## WEST SUSSEX COUNTY COUNCIL CONSULTATION

| <b>LOCATION:</b>                | Land adjacent to Community Centre, Westloats Lane, Bognor Regis, West Sussex, PO21 5JZ                                                                                                                                                     |
| <b>SUBJECT:</b>                 | BR/222/18/PL<br>Erection of 4no. 2 bedroom dwellings with associated parking & landscape.                                                                                                                                                  |

Figure: Proposed Site Plan

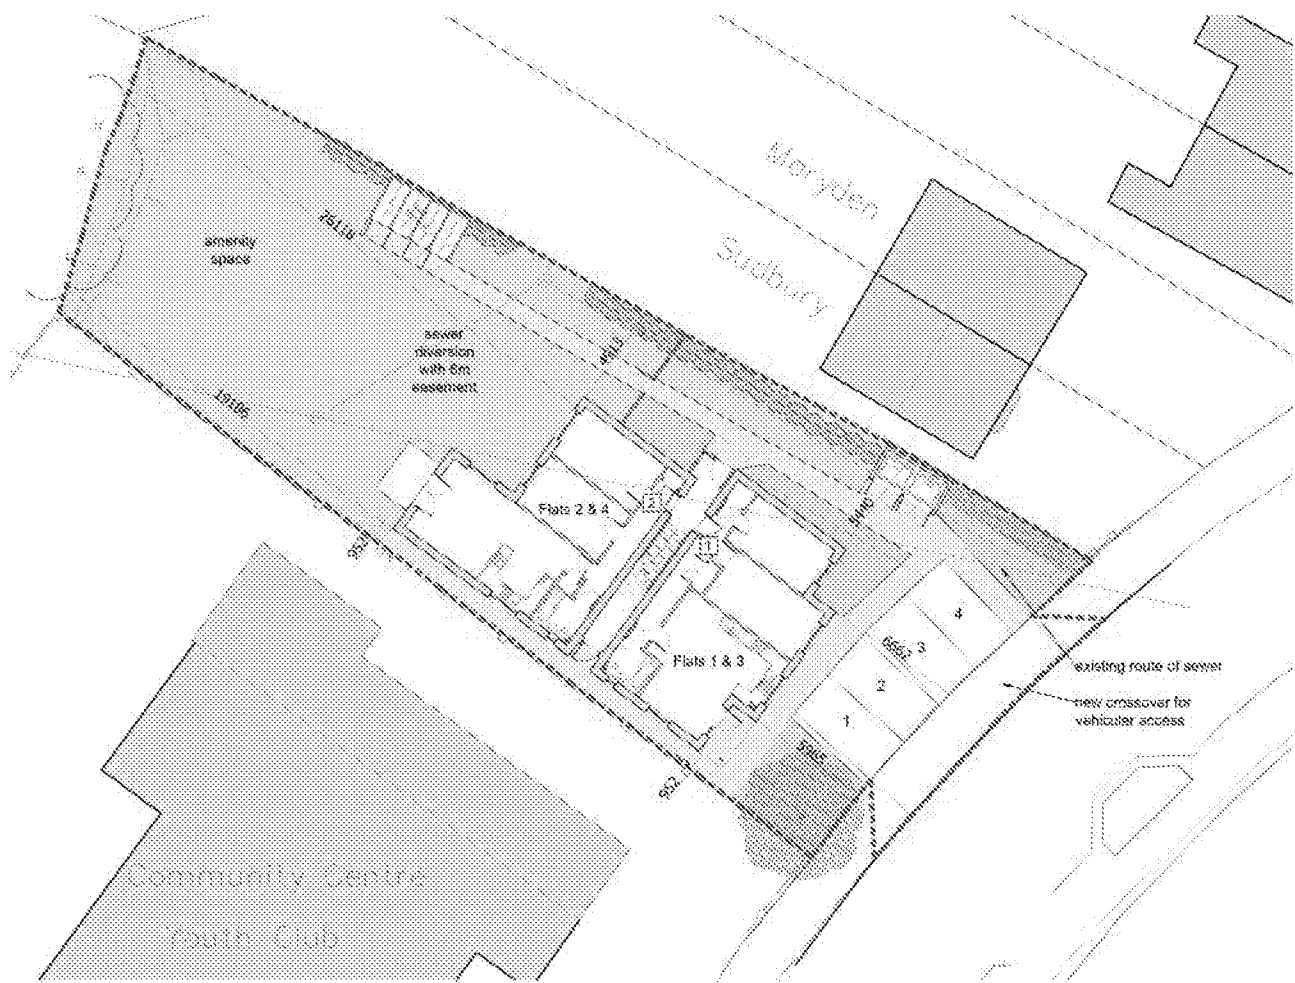
Four parking spaces have been positioned within the site frontage to accommodate for vehicles within the development. The dimensions of the spaces meet WSCC standards for a single parking space and appear a workable solution for parking within the site. A single parking space has been assigned to each dwelling. From observation of WSCC Parking Demand Calculator (PDC) this development would generate the requirement for 6 parking spaces.

The applicant has not demonstrated achievable visibility for vehicles or pedestrians however. This should be completed prior to occupation as per the below diagrams. Vehicular visibility should span in both directions to the nearside edge of the highway and intersect only land within the highway boundary or within the applicants' ownership. A set-back distance (X distance) of 2.4m should be used to demonstrate this. The splays must not intersect third party land. A suitable condition has also been suggested below.

No part of the development shall be first occupied until maximum achievable visibility splays have been provided at the proposed site vehicular access onto Westloats Lane in accordance with plans and details to be submitted to and approved in writing by the Local Planning Authority. Once provided the splays shall thereafter be maintained and kept free of all obstructions over a height of 0.6 metre above adjoining carriageway level or as otherwise agreed.

No part of the development shall be first occupied until pedestrian visibility splays of 2 metres by 2 metres have been provided either side of the proposed site vehicular access onto Westloats Lane in accordance with plans and details to be submitted to and approved in writing by the Local Planning Authority. These visibility splays shall thereafter be kept free of all obstructions over a height of 0.6 metre above adjoining carriageway level or as otherwise agreed.
